SETTLERS RANCH SUBDIVISION FILING NO. 3

A REPLAT OF A PORTION OF SETTLERS RANCH SUBDIVISION FILING NO. 2C, AND A PORTION OF SETTLERS RANCH ROAD, FILING NO. 2B, LOCATED IN A PORTION OF THE SOUTHEAST QUARTER (SE1/4) AND A PORTION OF THE SOUTHEAST QUARTER OF THE NORTHEAST QUARTER (SE1/4 NE1/4) OF SECTION 23, AND THE SOUTHWEST QUARTER (SW1/4) OF SECTION 24, ALL IN TOWNSHIP 11 SOUTH, RANGE 66 WEST OF THE 6th P.M., EL PASO COUNTY, COLORADO.

REVISED: JULY 3, 2024
DATE OF PREPARATION: JULY 31, 2023
PFD FILE #: SF2349

V2_Final Plat Drawings comments.pdf Markup Summary

SETTLERS RANCH SUBDIVISION FILING NO. 3
PT. SEC. 23 & 24, T11S, R66W, EL PASO CO., CO

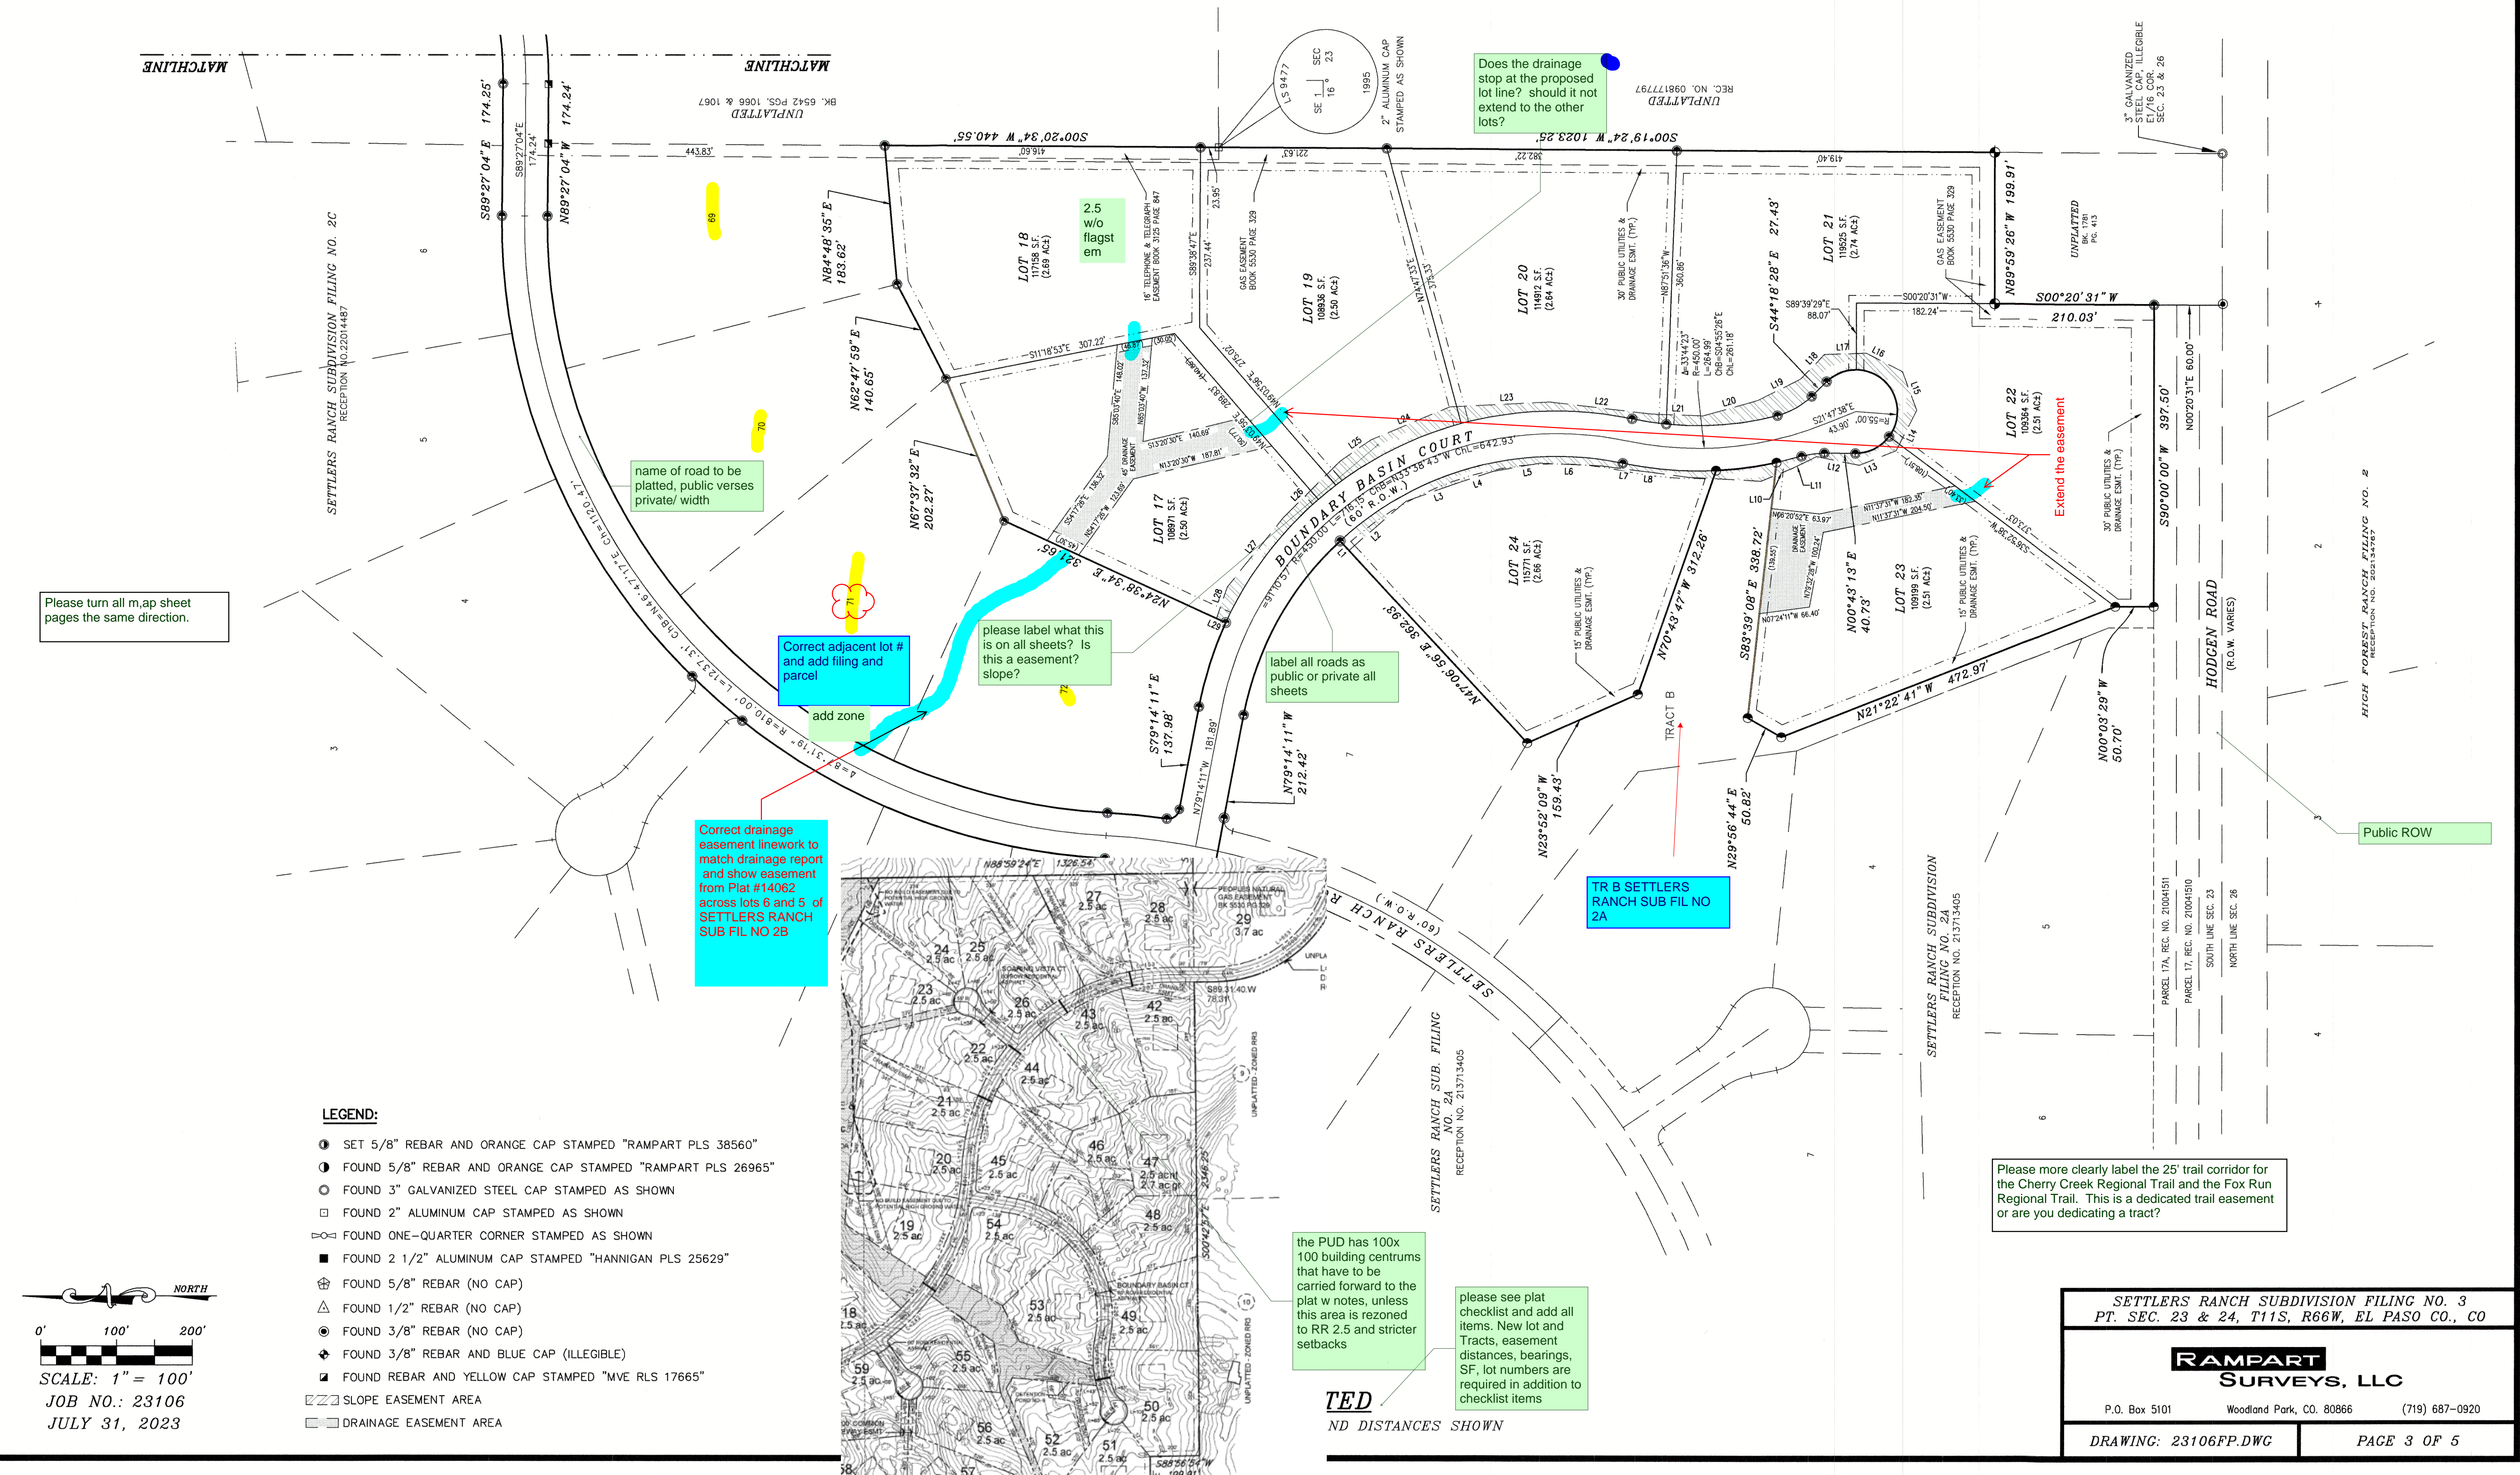
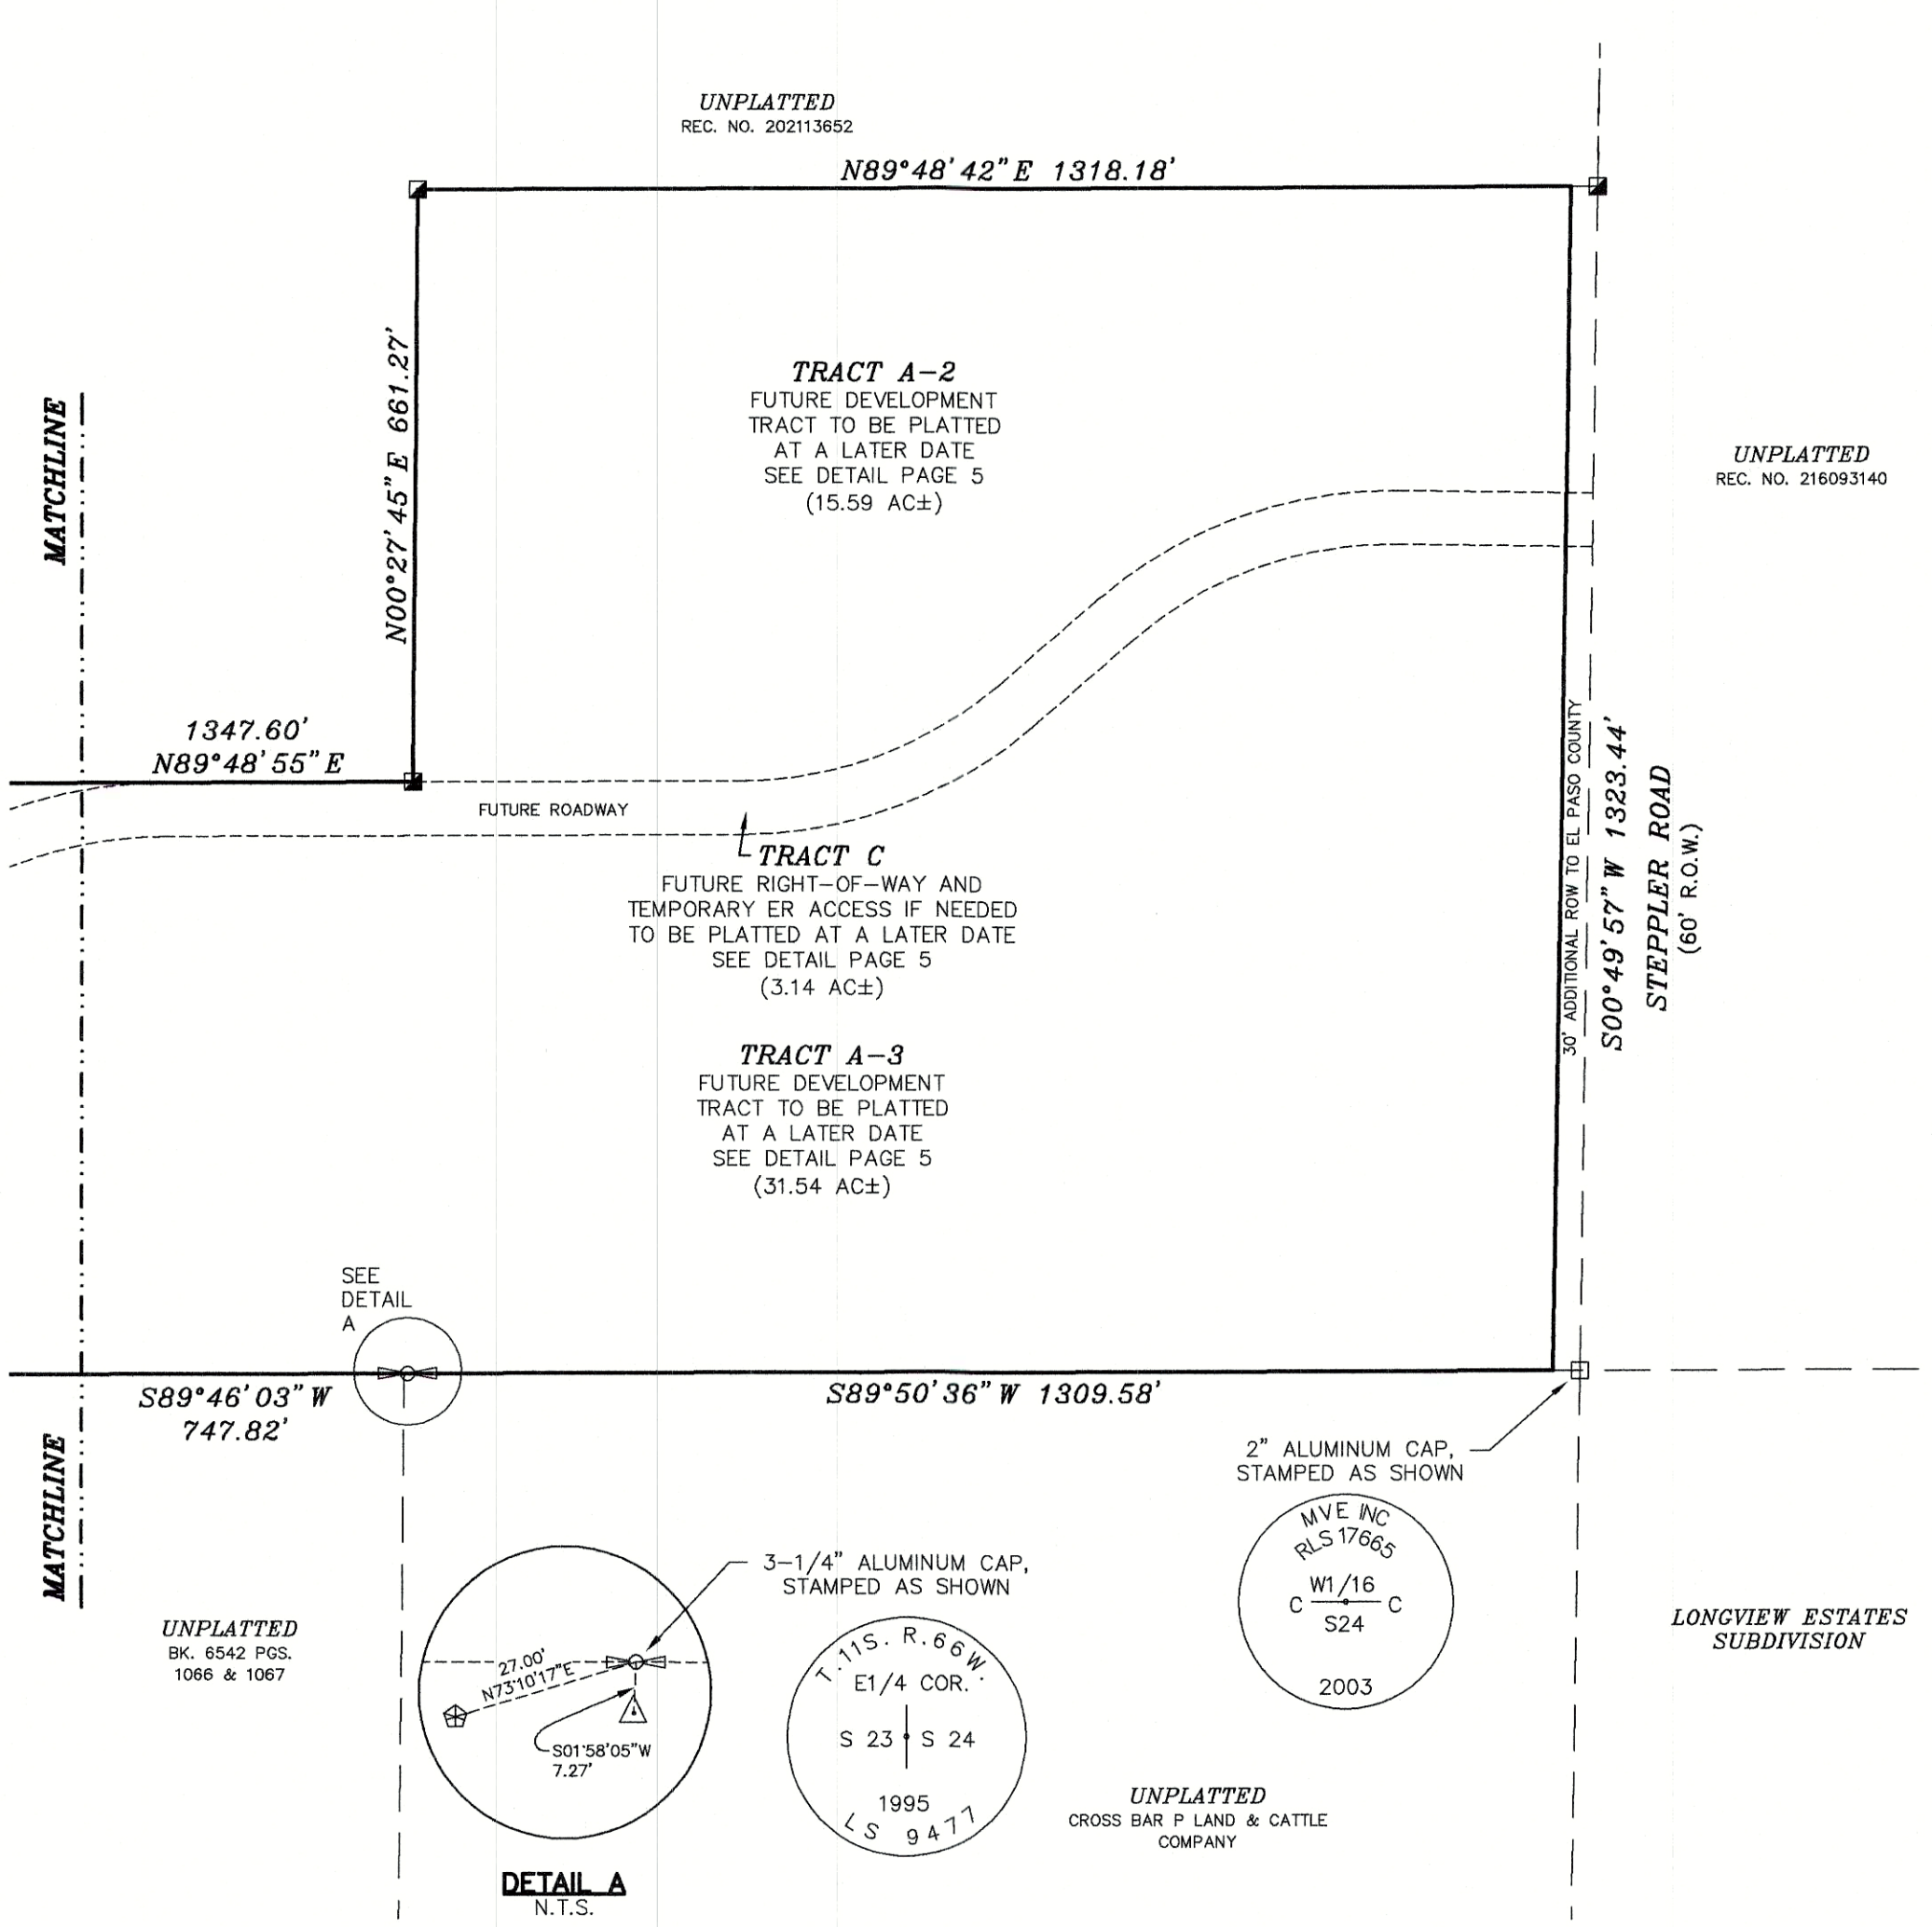
Is this an existing easement and then you are creating new easements w this plat? Does this easement go away?

Update #
lots

no report on file delete 2 delete this will be RR2.5 not PUD

setbacks still incorrect. RR2.5 zoning applies just like RR 2.5
